Re: Plans for 2 Bulbourne Close, HP4 3QA Ref: 22/01214/FHA

<b>CLIENT:</b>	Mr and Mrs Hill
<b>PROPOSED:</b>	Front extension and upward extension with alterations
<b>LOCATION:</b>	2 Bulbourne Close, Northchurch
<b>SCALE:</b>	1:50, 1:100, 1:200
<b>DATE:</b>	11/05/2022
<b>REF:</b>	Wren naj 19e 2022
<b>REVISION:</b>

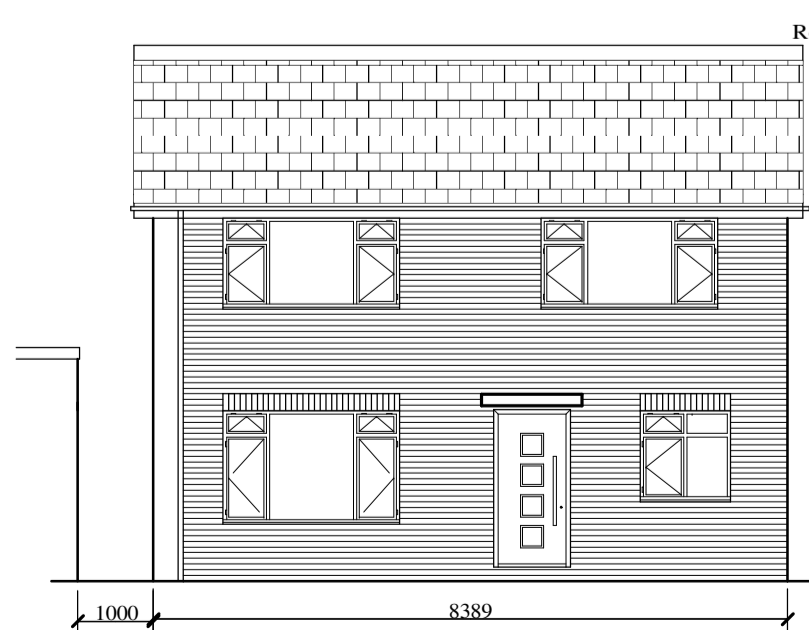
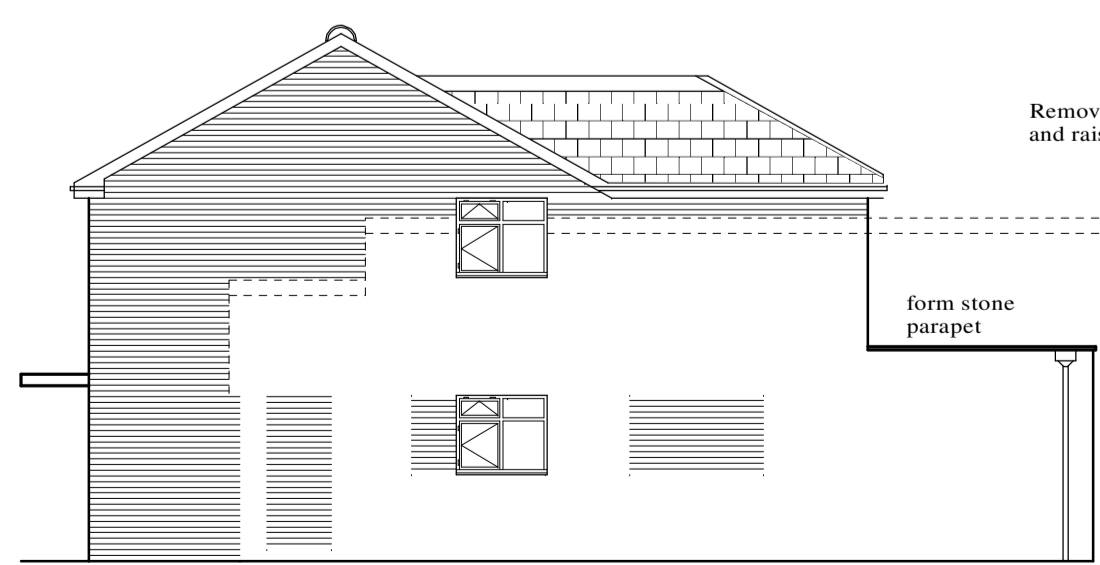
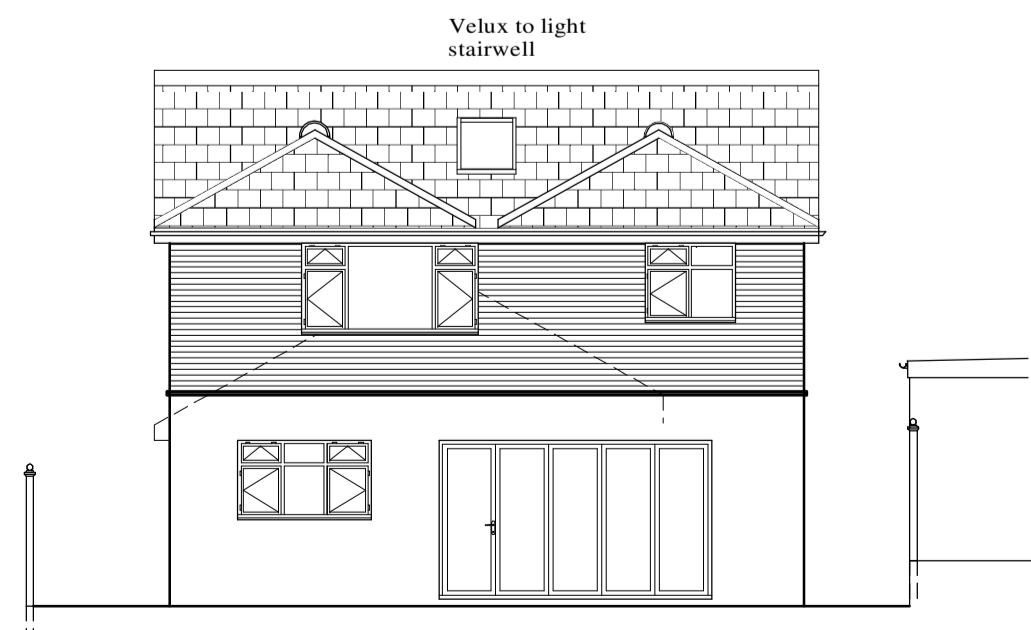
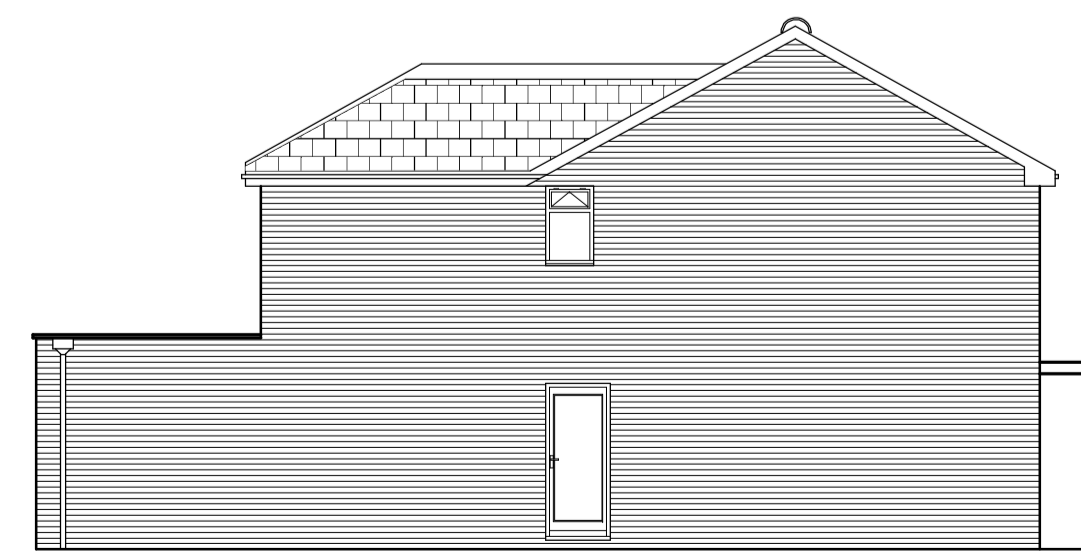
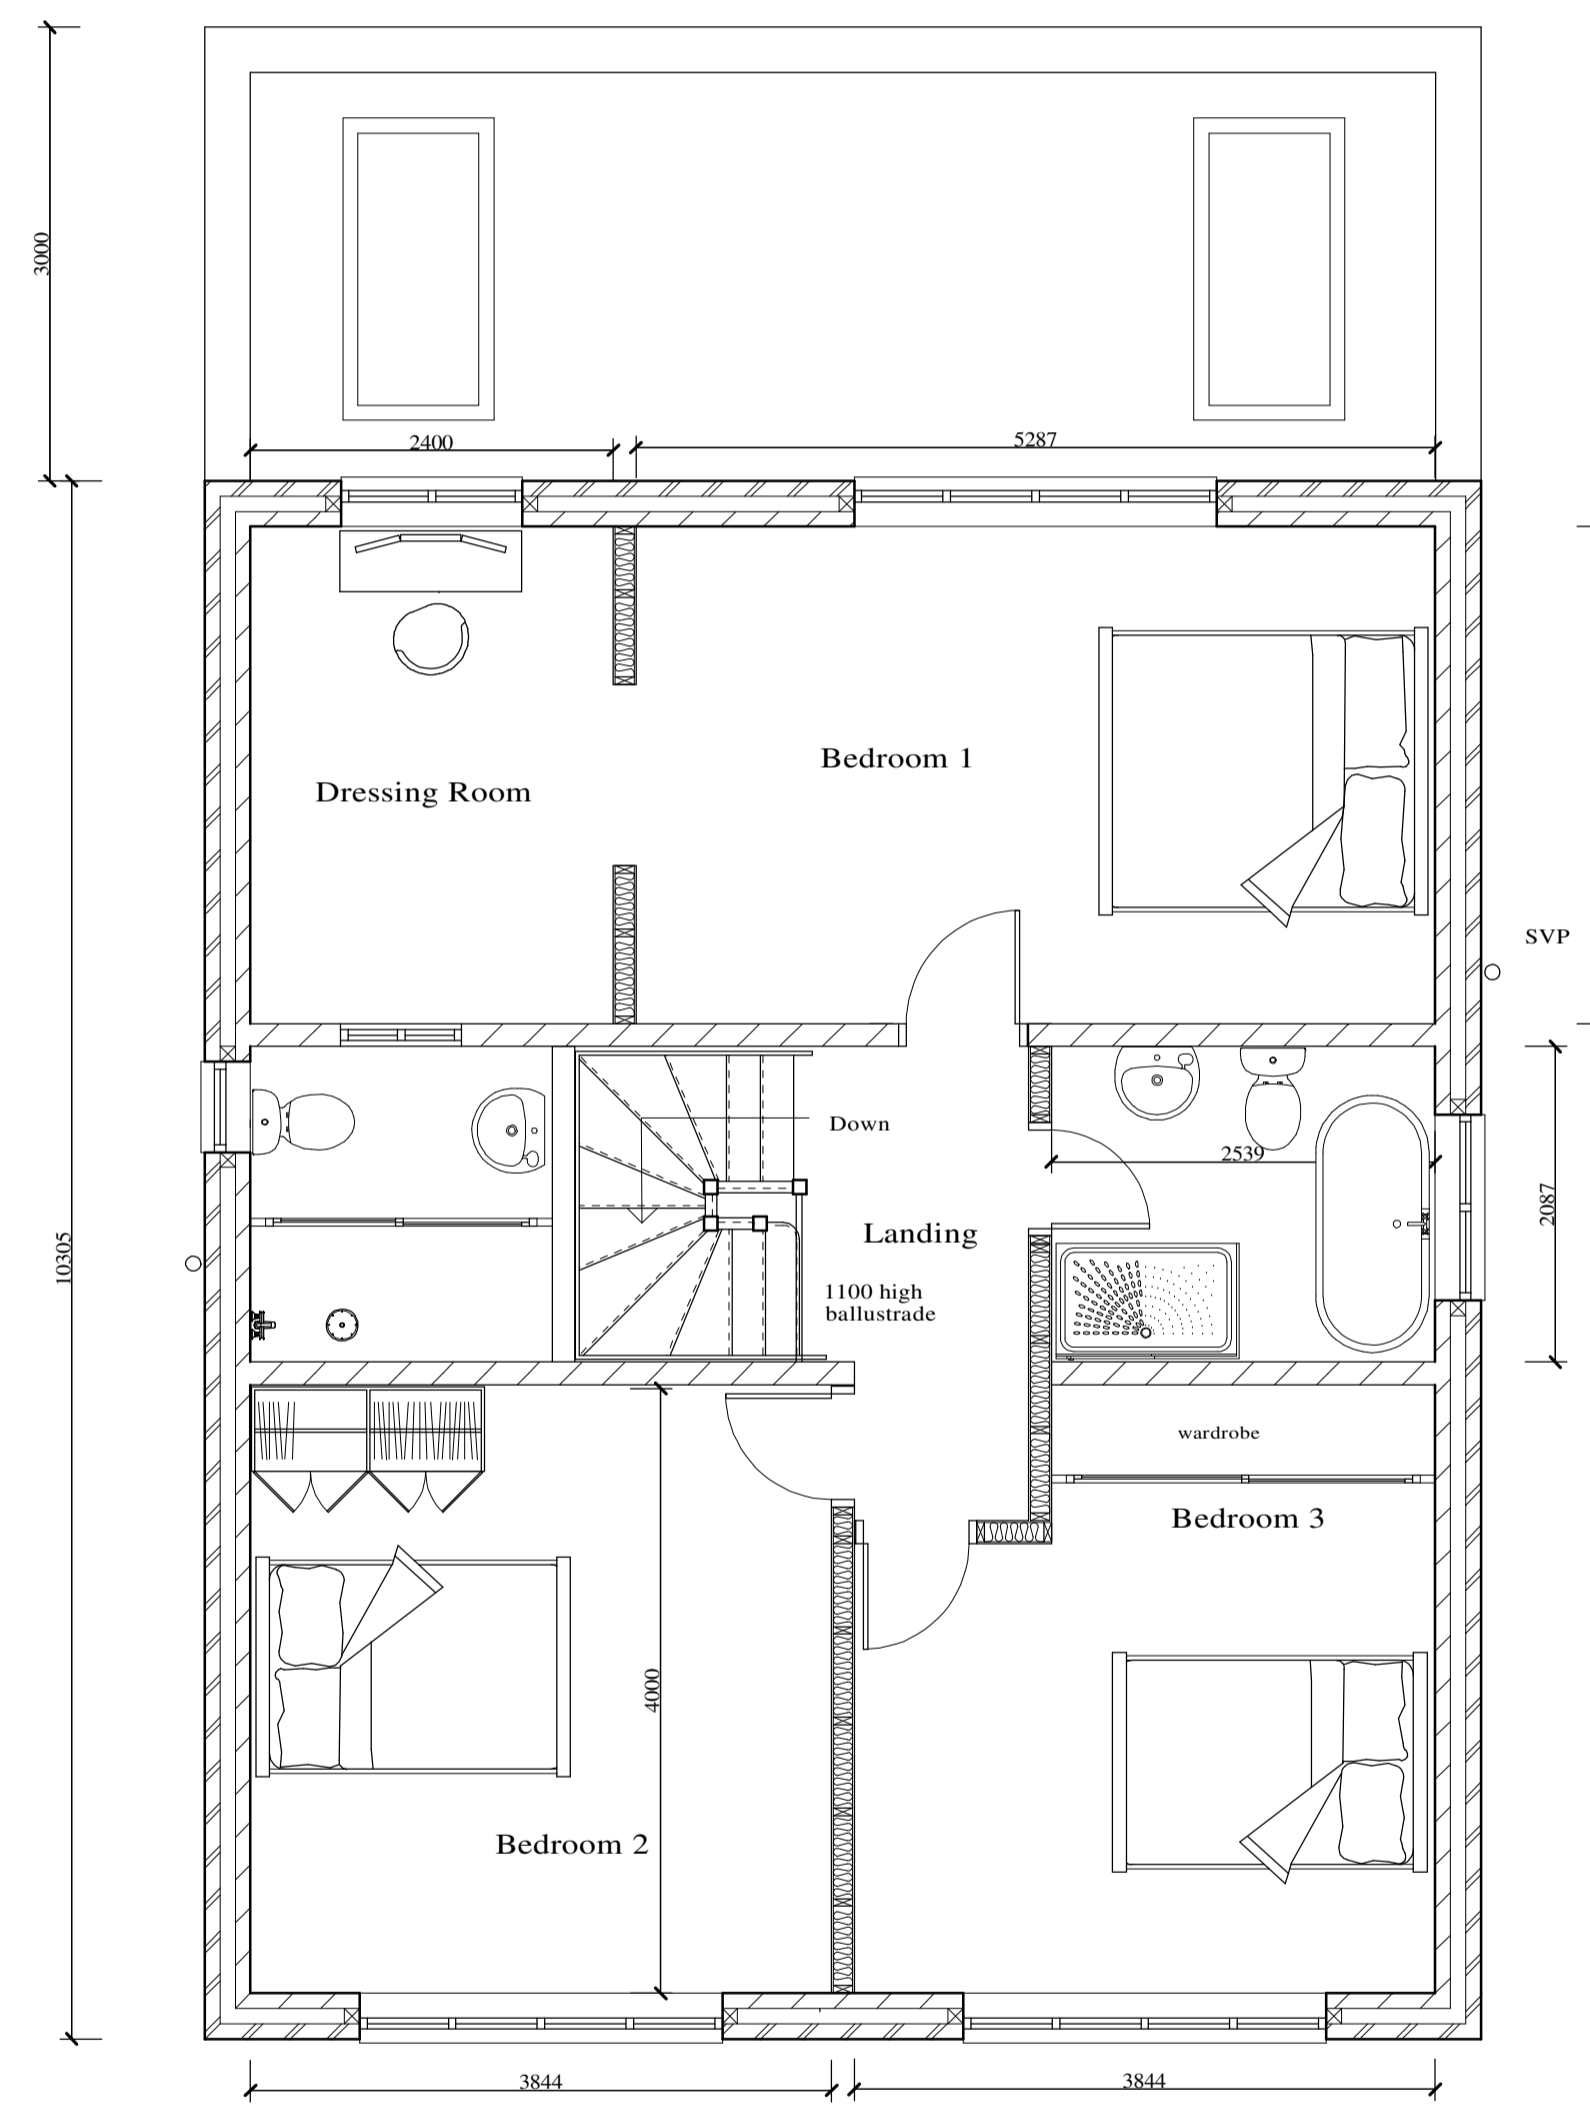
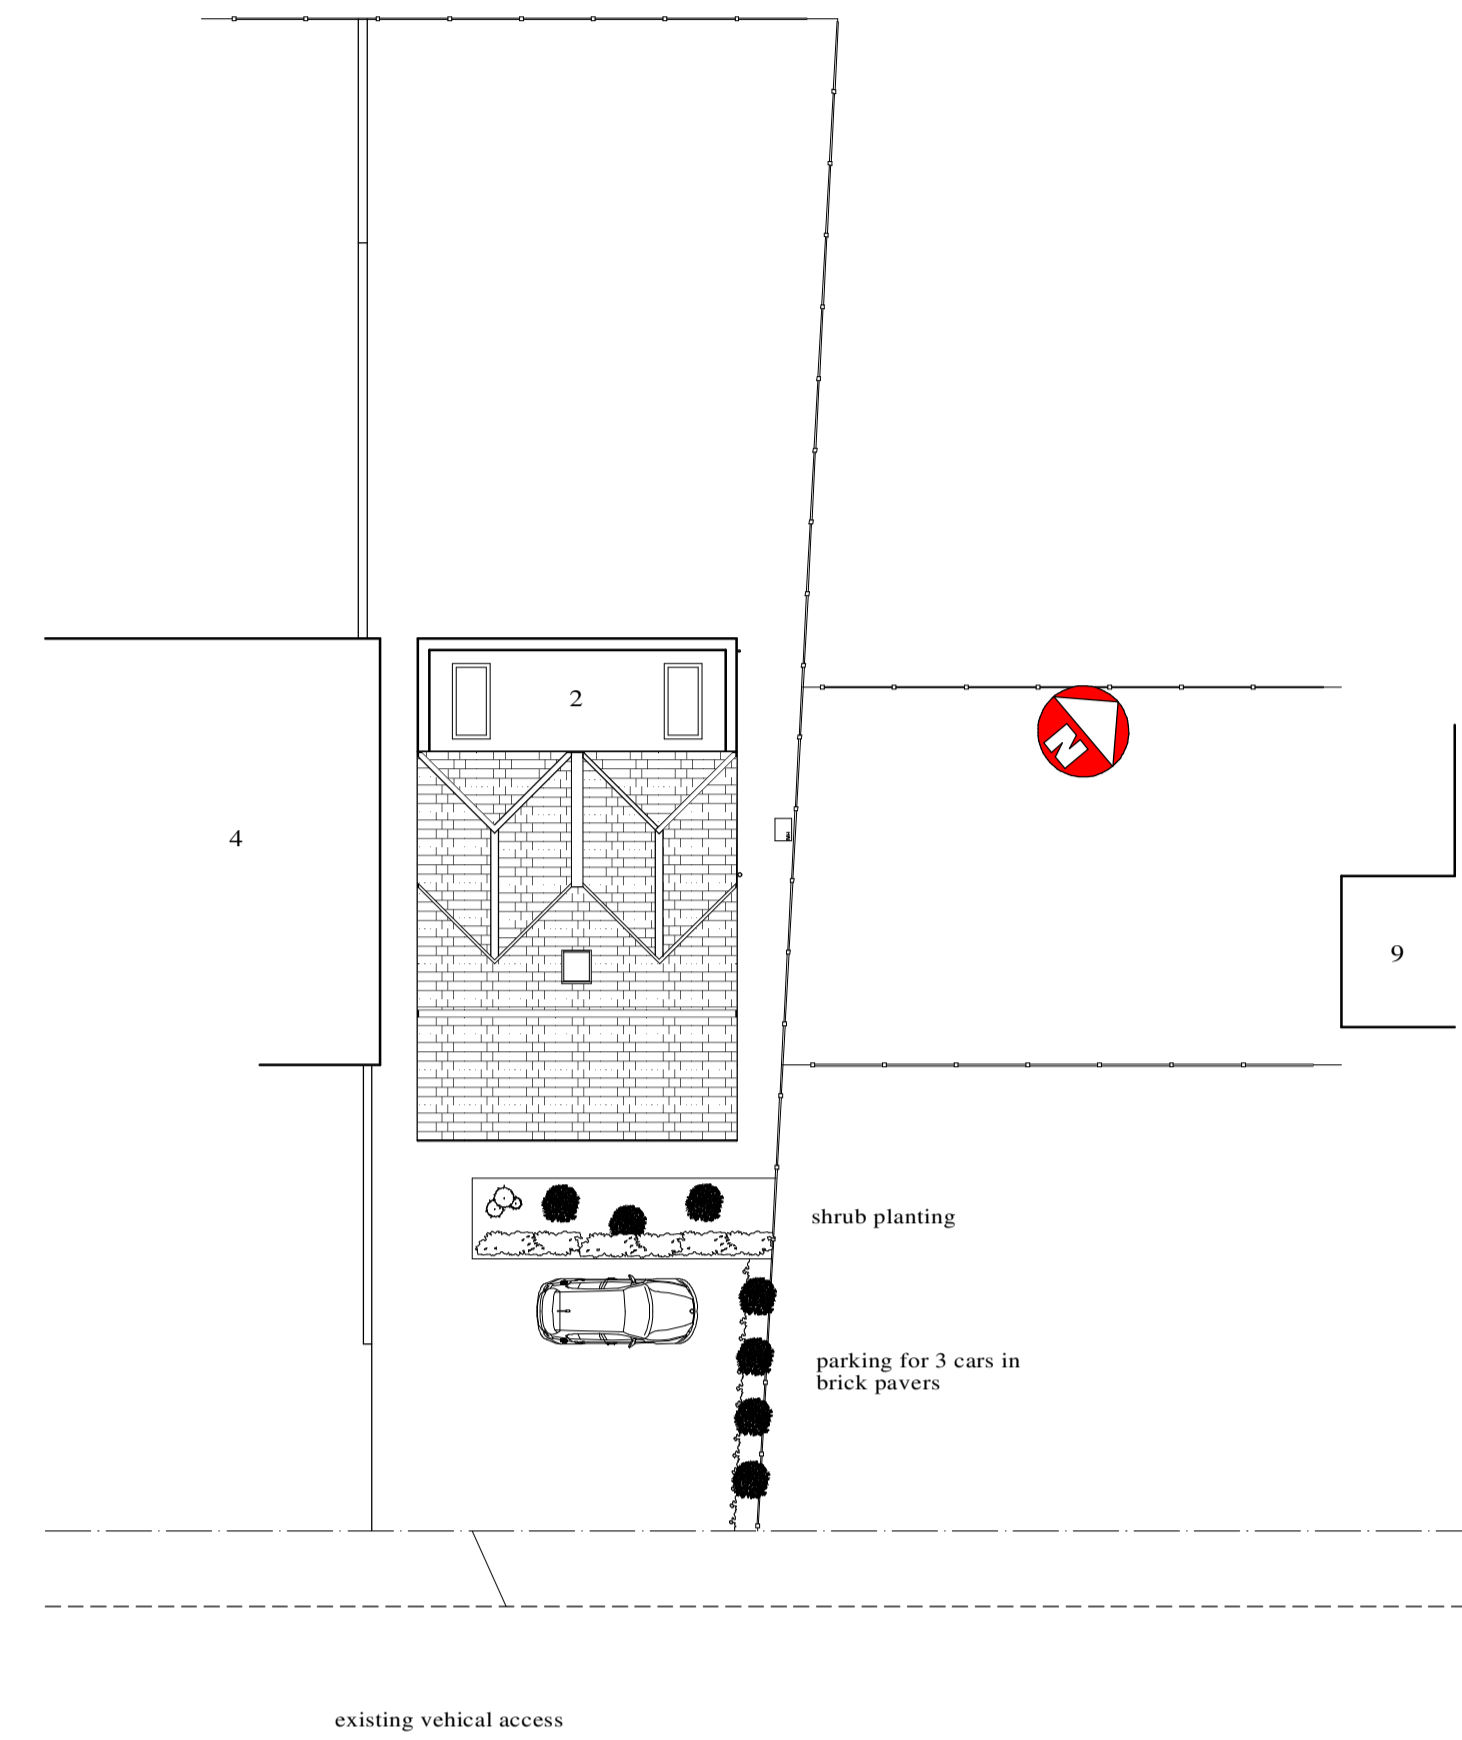
1. The properties are built on what were watercress beds. I am worried that the building of a double storeyed detached house could cause subsidence particularly to my property.
2. There is a partial difference in height between my garage and the one presently at No 2. The plans propose that the garage at No 2 be removed. This may cause slippage and subsidence particularly to my garage.
3. The conversion of No 2 would cause the existing internal wall between the two garages to become an external wall for my property No 4 with ensuing heat loss a probability from my property. The exposed wall would be north-facing.
4. Bulbourne Close would lose much of its 'open plan' character which attracted several of its present residents to live here; to bring forward the front of a house forward so much would change this aspect detrimentally.

5. There would be loss of some privacy in rear gardens and internal rooms in some adjoining properties by being overlooked from the proposed new bedrooms at No 2.
